Recommendation Report for Planning Permission for Works or Extension to a Dwelling

REF NO: EP/108/14/HH

LOCATION: The House on the Bend
15 Sea Lane
East Preston

PROPOSAL: Removal of thatch roof of detached garage & replace with clay roofing tiles.
Resubmission of EP/29/14/

PROPOSED ROOF CLAY TILE

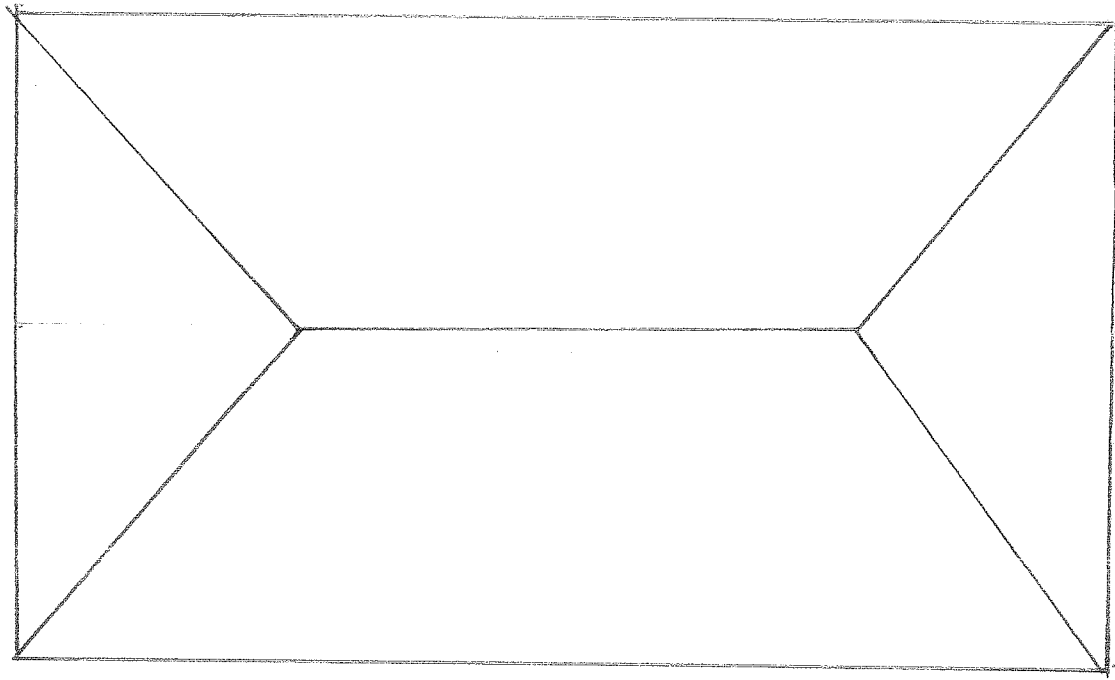
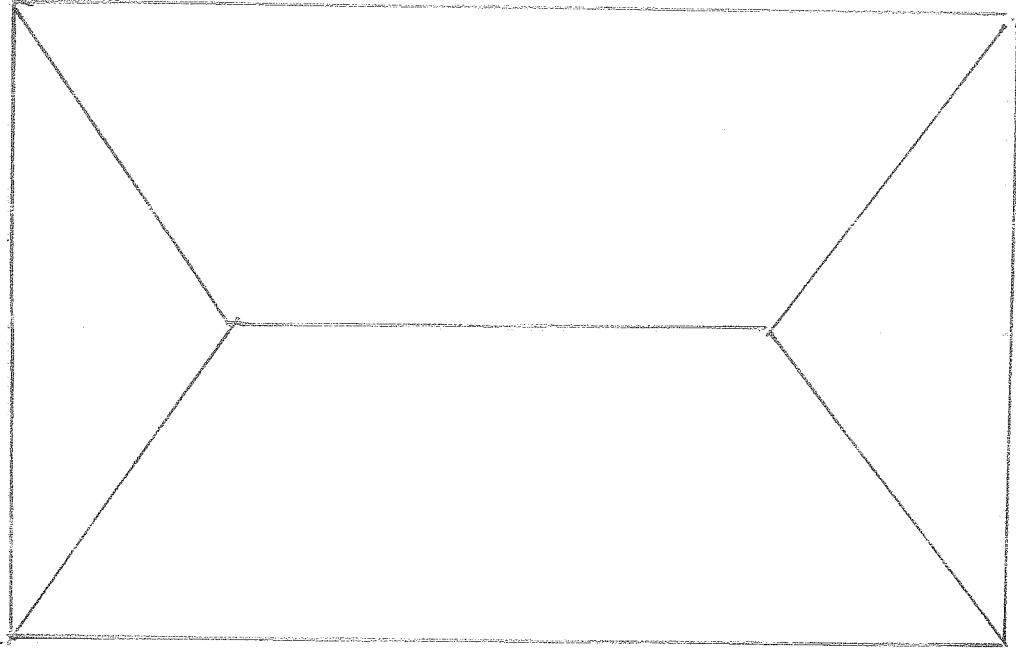
Whilst the loss of the thatch is not ideal with respect to the building's character, the retention of the roof form and the proposal to replace with a good quality tile can be supported in this instance. The retention of the roof profile does allow for thatch to be reinstated in the future should it be desired. Please condition the roof tile which ideally should have a double camber to provide a soft and textured appearance to the roof.

- 5 INFORMATIVE: The applicant is to be made aware of the Historic Building Advisor's comments in recommending that the roof tile should ideally have a double camber to provide a soft and textured appearance to the roof.

Comments noted. A materials condition will be recommended to secure an appropriate roof tile.

- 3 No development shall be carried out unless and until a schedule of materials and finishes and samples of the roof tile to be used on the detached garage have been submitted to and approved by the Local Planning Authority and the materials so approved shall be used in the construction of the roof.
